DA NO: 25-2009-3-3

PROPOSAL: Modification to Residential Subdivision for 411 lots (MOD 9)

**PROPERTY: LOT: 1 DP: 270466, LOT: 4 DP: 270466, LOT: 7 DP: 270466
1 Seaside Boulevard FERN BAY, 20 Seaside Boulevard FERN
BAY, 2 Seaside Boulevard FERN BAY**

Thank you for your email dated 16 May 2017, inviting Council to provide comments to the proponent's response to submissions. Council has completed a review and provides the following advice:

STAGES 18 & 19 DETAIL PLAN REV N

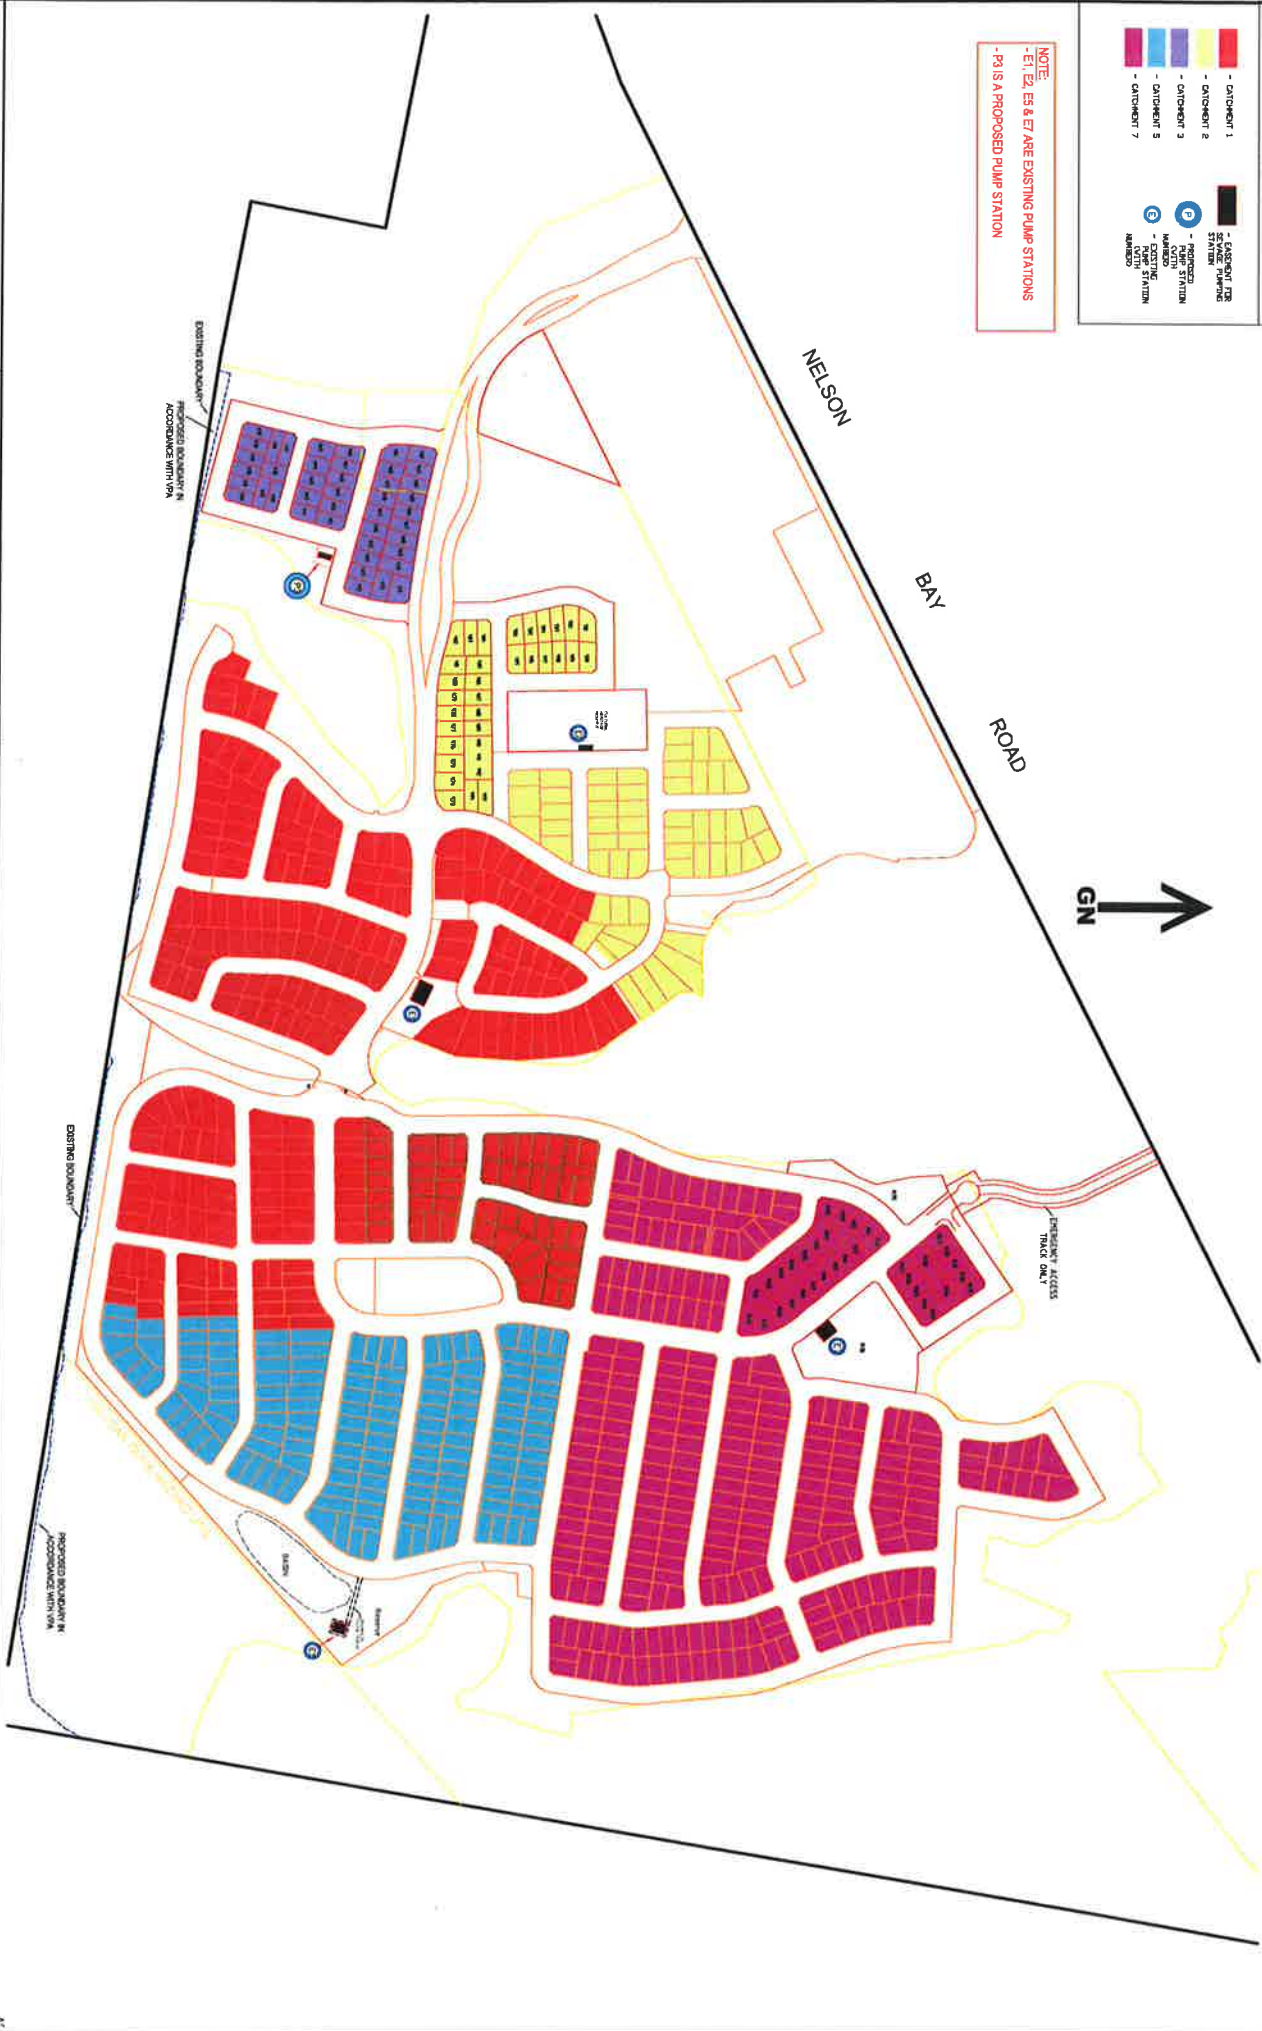
Council's concerns raised have not been adequately addressed. Based on the information provided for the proposed modification (MOD9) for Major Project 06_0250, modifications 2 and 4 associated with the proposed road around the reconfigured Stages 18-20 (MOD2) and relocation of the proposed pump station P3 (MOD4) are not supported as potential ecological impacts have not been adequately considered or assessed.

To date, the documentation provided has not provided adequate justification for the encroachment of the road and batters into the E2 zoned retained vegetation management area. Both proposed modifications are located within vegetation mapped

The proposed accesses to stages 19 and 20, from Seaside Boulevard need to be consolidated. The left-in/left-out required would be inconvenient for residents and would result in unsafe u-turns being performed on Seaside Boulevard. A roundabout combining both accesses and allowing all movements to both stages would be a much preferred outcome.

Council recommends that if impacts to biodiversity within the E2 zone are considered unavoidable, an ecological assessment of the proposed modifications is required to assess the potential ecological impact of the proposed modifications (1-4), particularly proposed modifications 2 and 4. Any clearing of preferred koala habitat would require adequate justification and compensatory measures provided.

DRAWING TITLE
FLOOD PRONE & LOW LYING AREAS REV-N

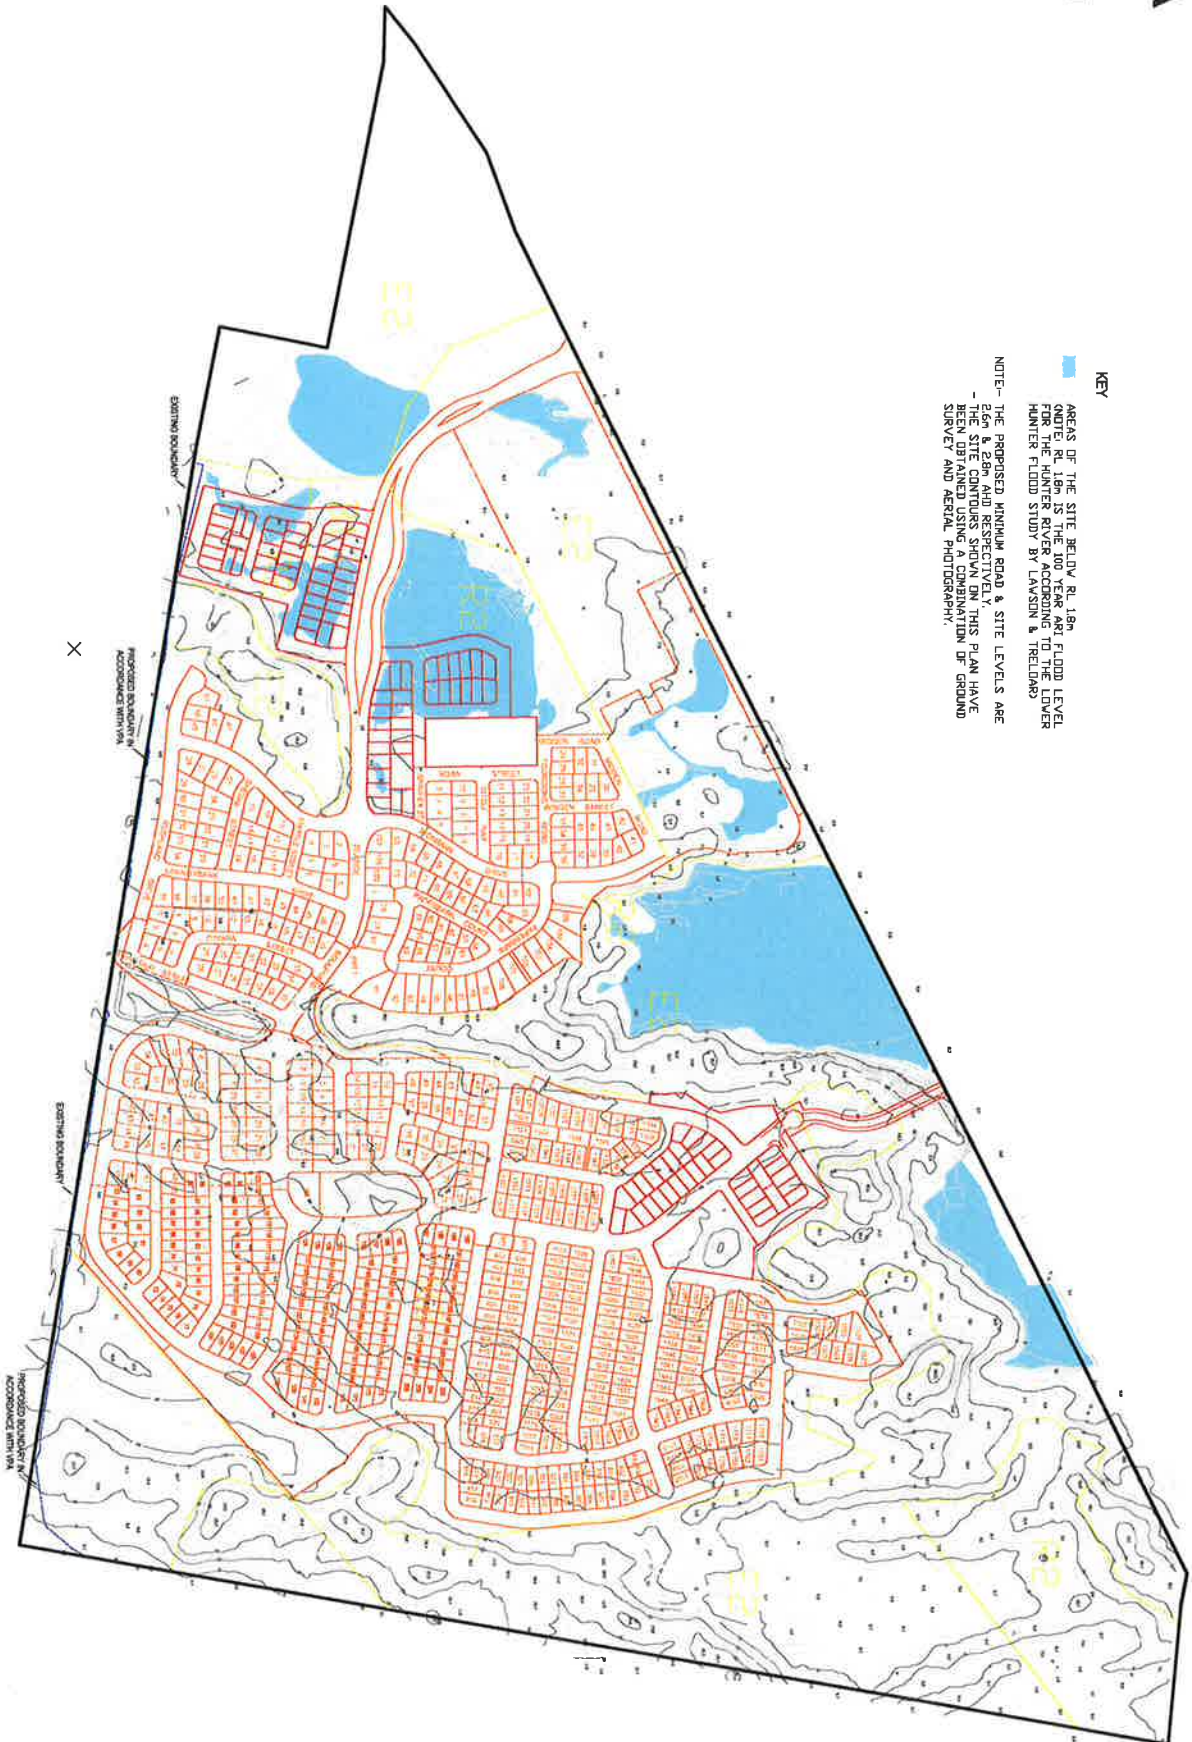
Approximately half of the property is flood affected within the category 'low hazard – flood fringe'. The future floor levels of habitable buildings should be above the flood planning level.

The majority of the area is low-lying and the low-lying area is affected by a perched water table. This matter requires consideration when designing a stormwater management system for any future development.
